J.S. THOMPSON
ENGINEERING, INC

October 19, 2023

The plan for the Cerrillos Residence was reviewed to address the framing at the left family room vaulted windows.

**HOUSE FLOOR PLAN**  
SCALE: 1/4"=1'-0"

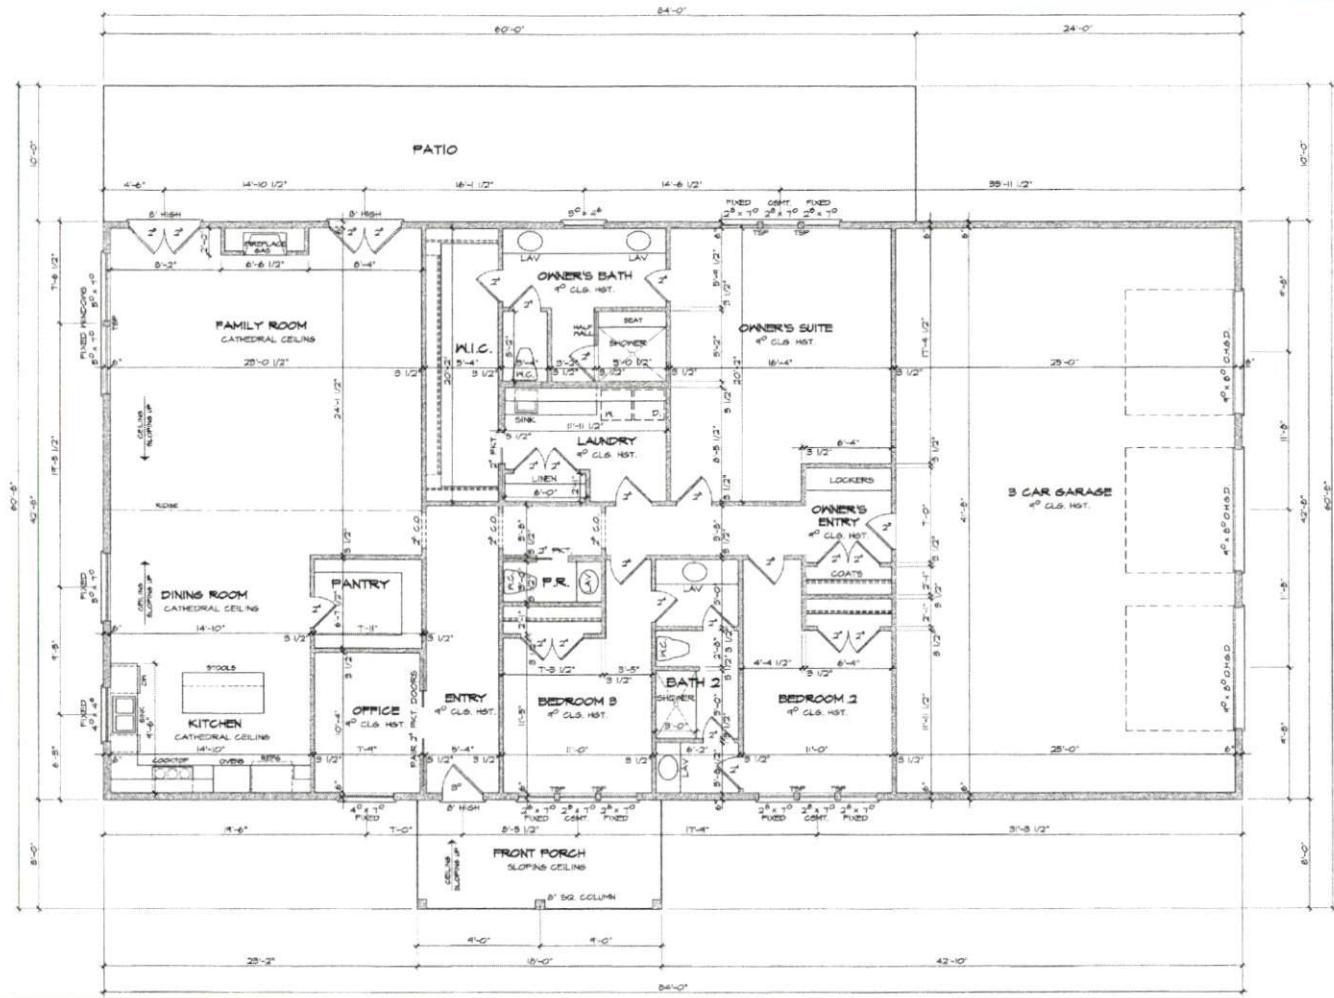
In lieu of the balloon framed stud pocket between windows per plan, the double window at the vaulted family room was framed with a continuous (3) 2 x 6 header between the upper and lower windows with a triple stud pocket below and above the header secured with Simpson CS16 straps. Analysis revealed modifications are required. A (3) 2 x 8 SPF #2 or SYP #2 continuous header that follows the roof line is required above the upper window with (1) jack and (5) king studs at each end. King studs are to be fastened with (2) 12d toe nails at the top and bottom and (2) rows of 12d nails at 6" o.c. Secure the stud columns together each end with Simpson CS16 coil straps at 24" o.c. This configuration will provide the required support for all applied loads.
